Rezoning Transportation Analysis

Petition Number: #2022-107

Date	Description
11-28-22	First Review (IW)
12-22-22	Second Review (DR)
01-26-23	Third Review (IW)
03-22-23	Fourth Review (IW)

RZ1.00

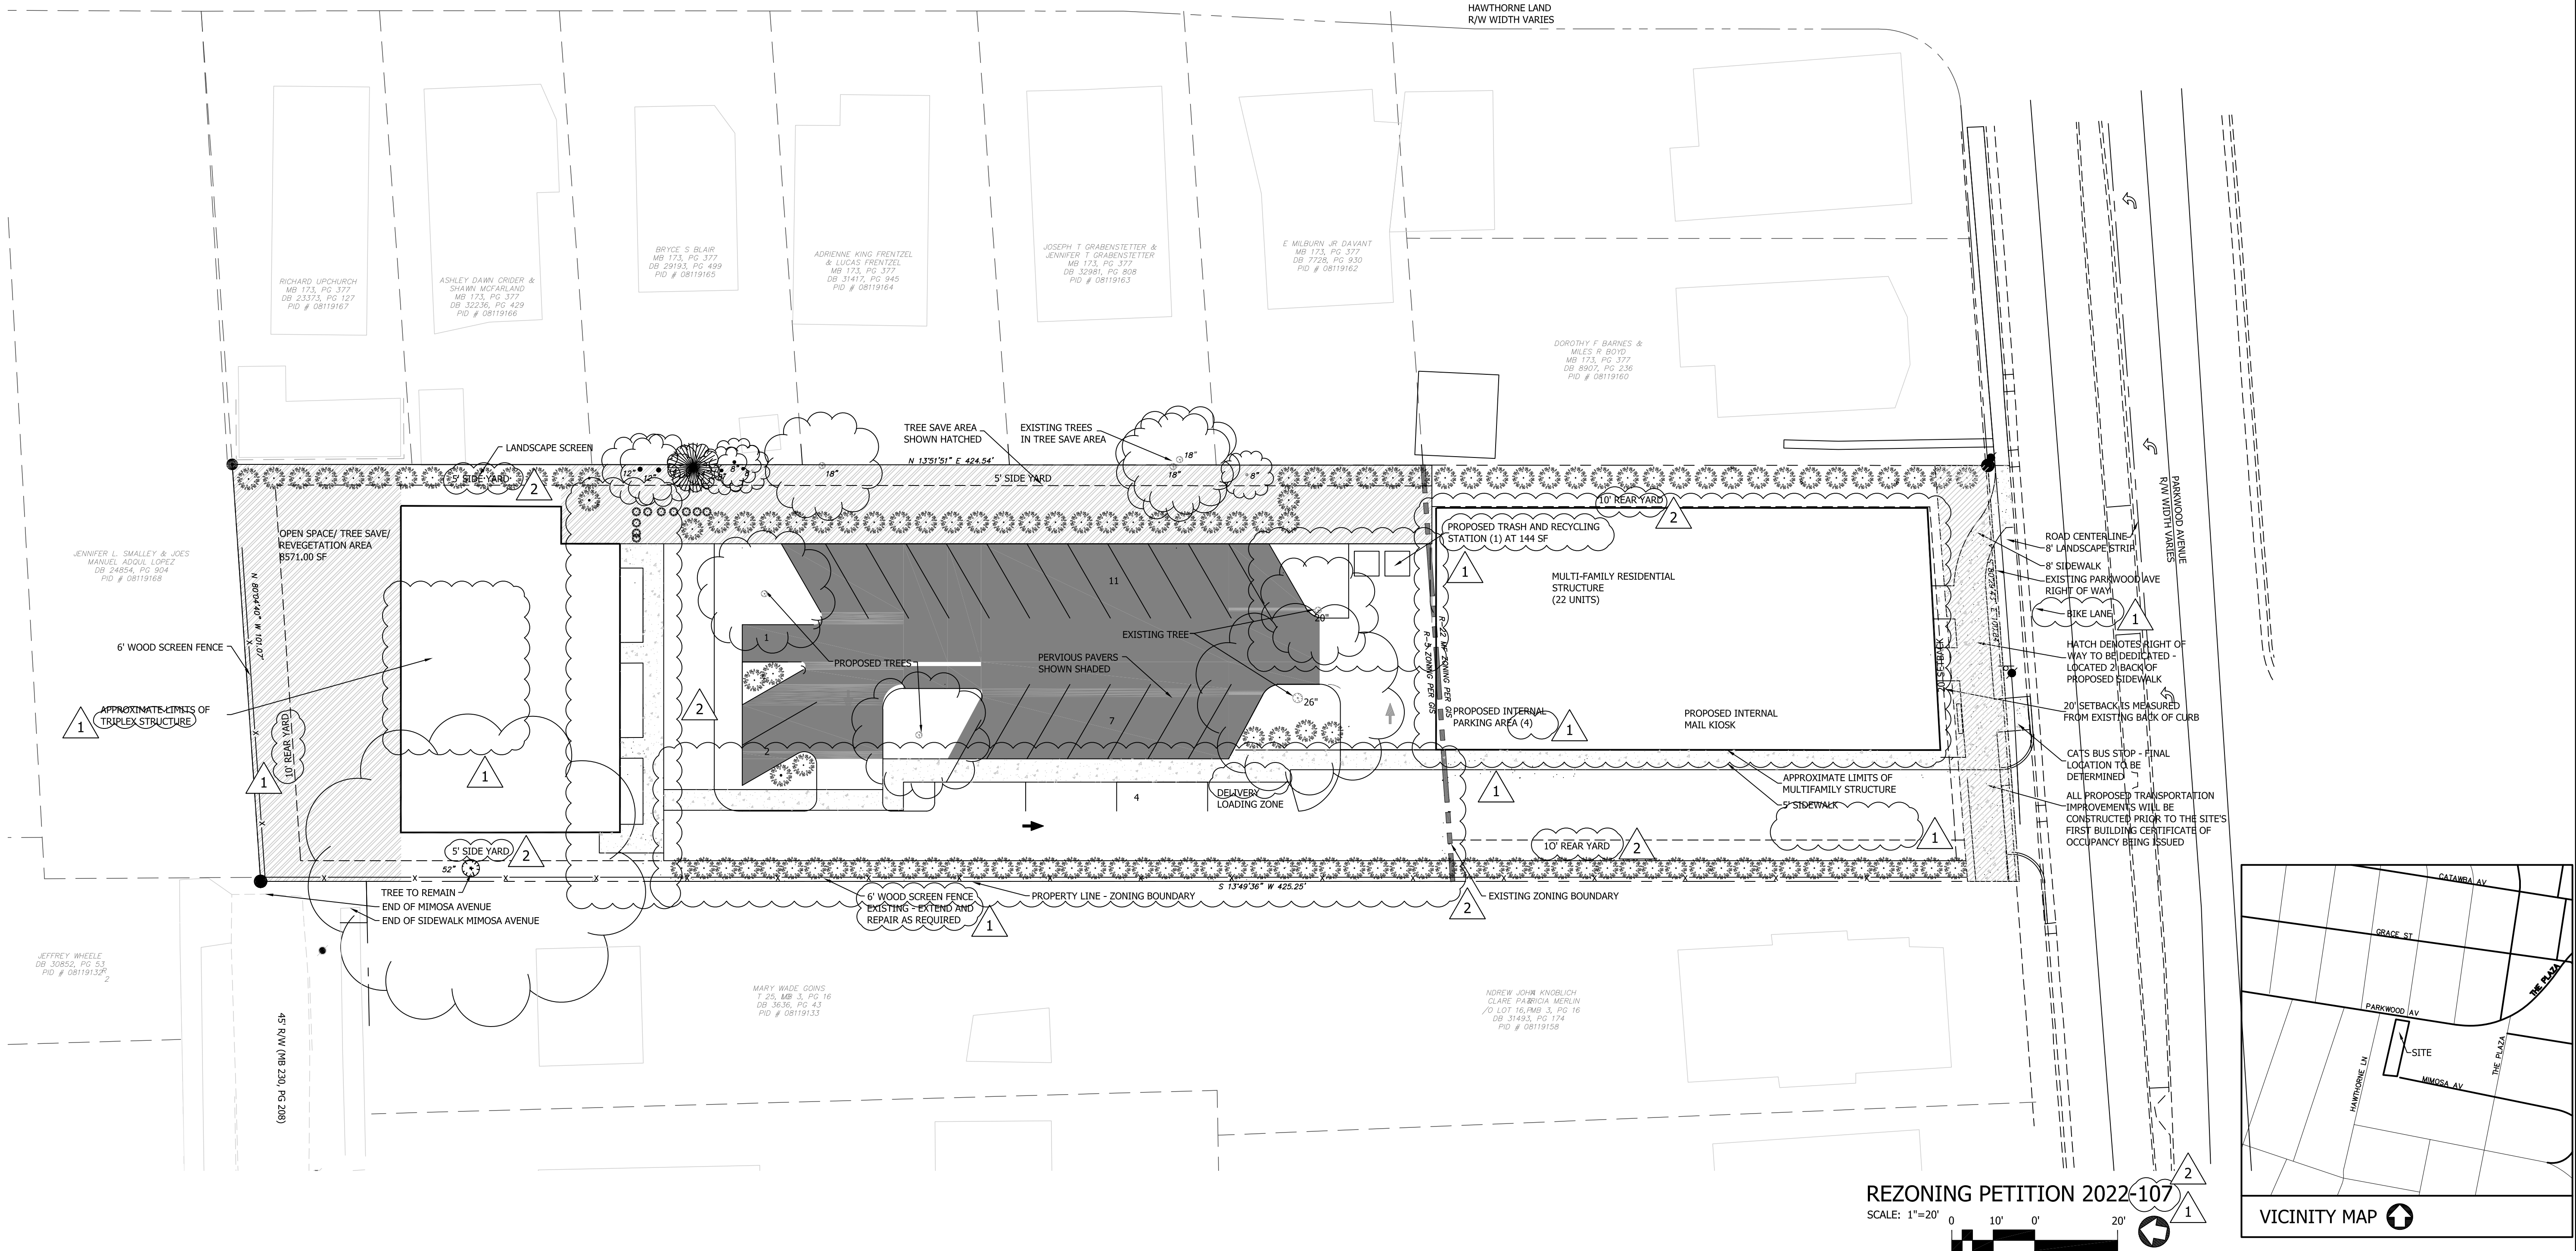
1. **Curblines:** The proposed zoning district has a setback measured from back of the existing or proposed future curblines.
 - a. **Parkwood Avenue:** Location of future back of curb and gutter is 38 feet from centerline.

Clarified Outstanding Comment from 11-28-22 Label and dimension the future curb and gutter from the centerline for each road on the site plan. Streetscape elements should be constructed at the back of future curb and gutter.

3. **Outstanding Comment from 11-28-22** Revise site plan and conditional note(s) to commit to dedicate 56 feet of right-of-way from the road centerline. The site plan shall label and dimension the right-of-way from the road centerline.

Clarified Outstanding Comment from 03-21-22 Site plan only shows hatched area, petitioner should label and dimension the right-of-way from the centerline for each road on the site plan.

Clarifying comment from 12/22/2022: Commit to connect sidewalk near single family structure to existing sidewalk on Mimosa Avenue as shown above.

Clarifying comment from 12/22/2022: Extend 8-foot sidewalk as shown above to property line along Parkwood Avenue.
